## Appeal Decision

### Appeal Ref: APP/R4408/D/25/3369938

#### 19 Wilthorpe Road, Redbrook, Barnsley S75 1JB

- The appeal is made under section 78 of the Town and Country Planning Act 1990 (as amended) against a refusal to grant planning permission.
  - The appeal is made by Mrs Sarah Parry against the decision of Barnsley Metropolitan Borough Council.
  - The application Ref is 2025/0057.
  - The development proposed is the replacement of existing boundary wall at front of property, with a combination of brick wall and fencing to a maximum height of 1.5 metre. (Approximately 1 metre of which would be solid and the upper approximately 0.5 metre would be a perforated style fencing). Extension to existing drive opening, new driveway gates and separate pedestrian gate, to tie in with the height and style of the front fencing to a maximum height of 1.5 metre. Widening of existing drop kerb to accommodate new driveway gates.
-

PROPOSED FRONT ELEVATION
SCALE 1:50

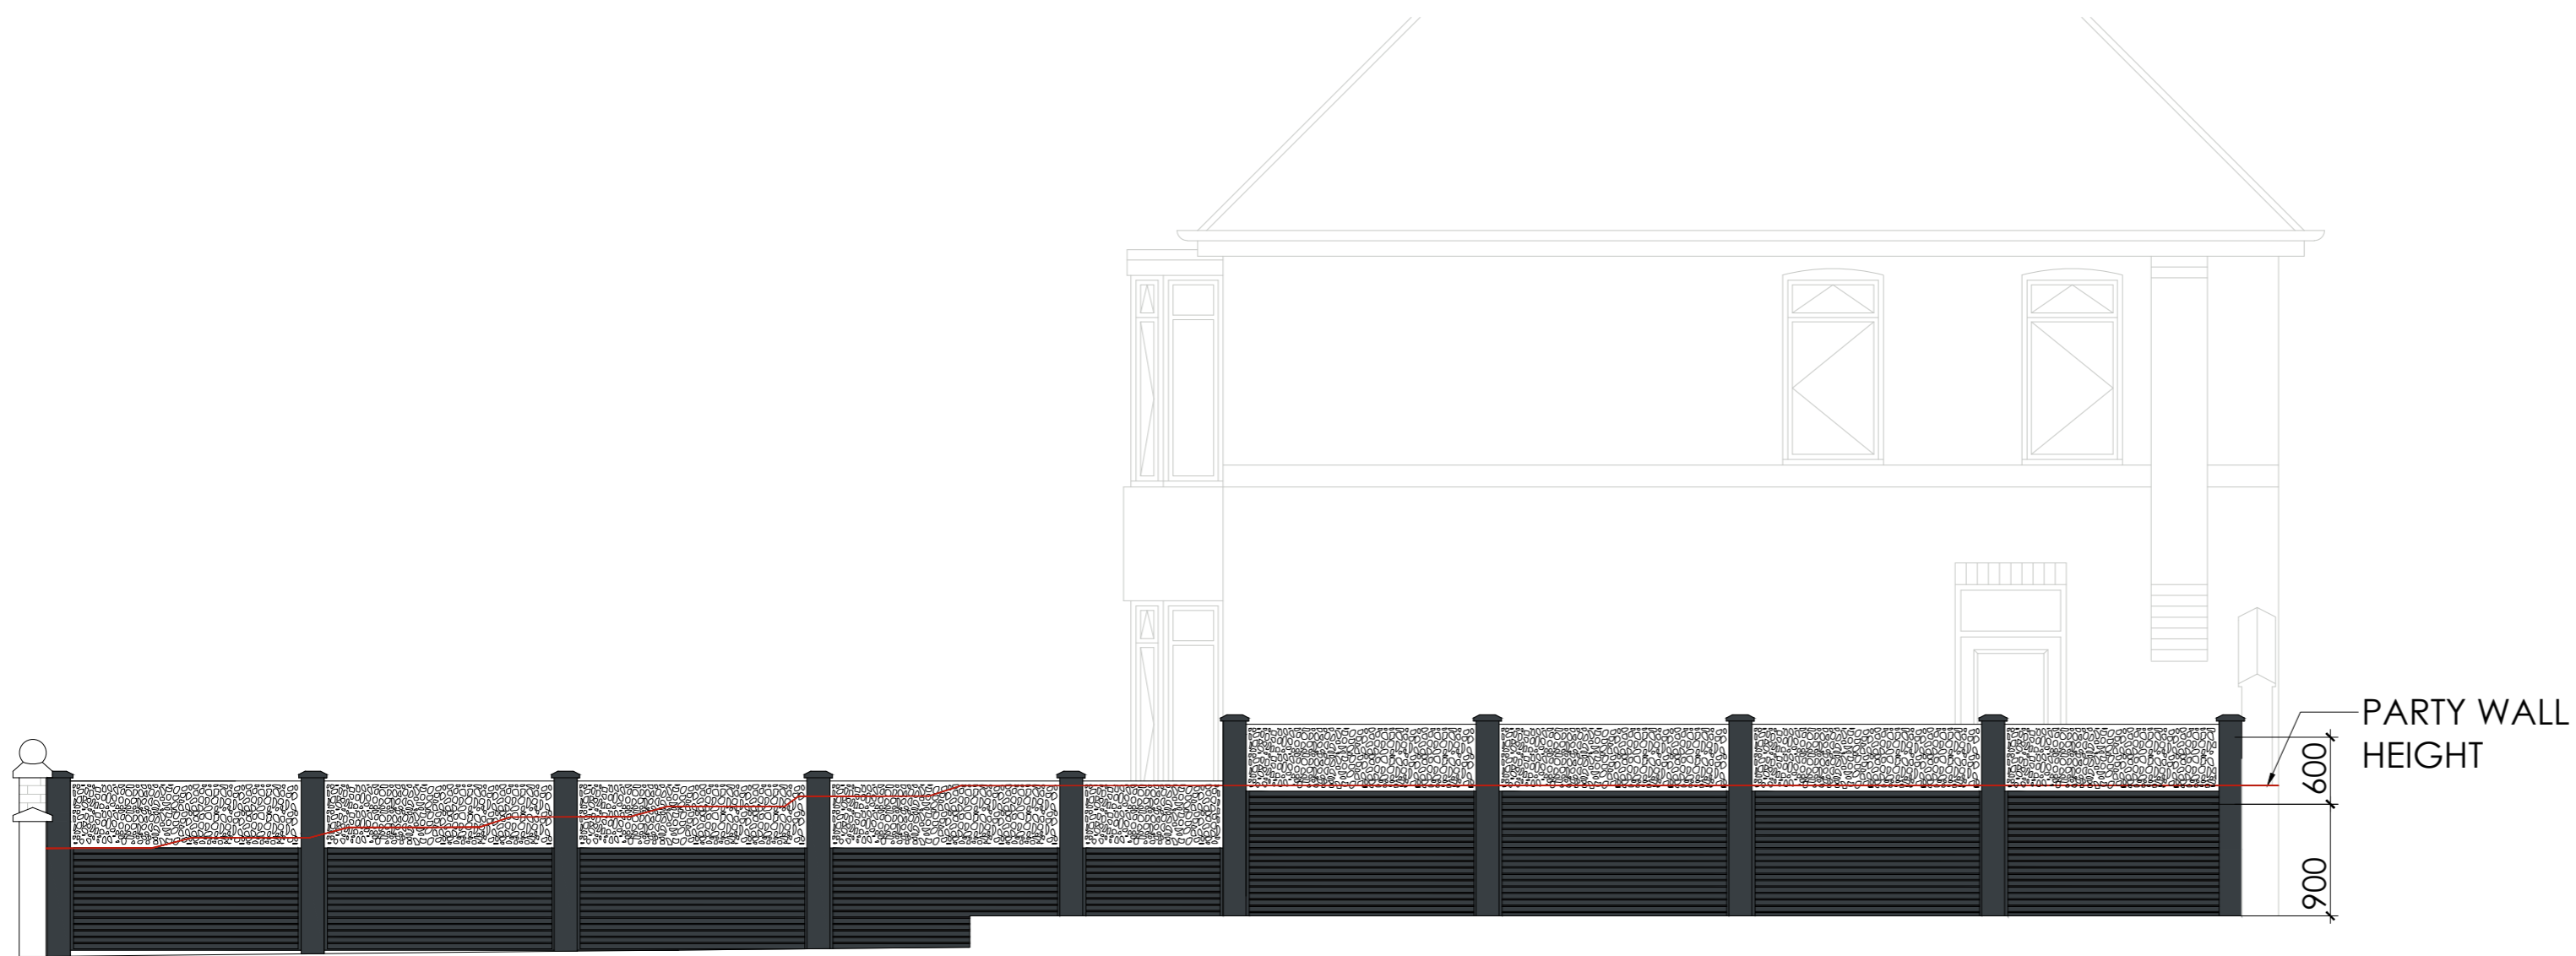
4. The proposals would, by virtue their overall height, be visually intrusive, creating a dominant and enclosing presence on the plot, contrasting sharply and unacceptably with the open and landscaped character of the surrounding area. The impact would be intensified by the extensive hardstanding that has replaced the former front garden, contributing to a harsher, more engineered appearance. While the proposed fencing above the wall would have a degree of permeability, its design and detailing would introduce elements that would appear incongruous and out of character with the surrounding area.

7. It is unclear as to whether a vehicle parking on the plot frontage would be able to turn within it to ensure it could always exit forwards. Even if such a manoeuvre were feasible, the driver's visibility would be significantly compromised by the height, position and solid nature of the gate pillars, wall and topped fence panels. This restricted visibility would increase the potential for conflict with pedestrians, cyclists, and other road users. Should a vehicle need to reverse into the plot, it would temporarily obstruct the carriageway, impeding the free flow of traffic when a vehicle would stop in the carriageway to commence the manoeuvre.

8. Conversely, should a vehicle have to reverse out of the access, there is potential for the same effect for the same reasons, with the added problem of more of the exiting vehicle occupying the public highway before the driver would be able to see sufficiently well into the carriageway. This would be exacerbated by the constantly active nature thereof. The scheme would therefore be unacceptable in highway safety terms.
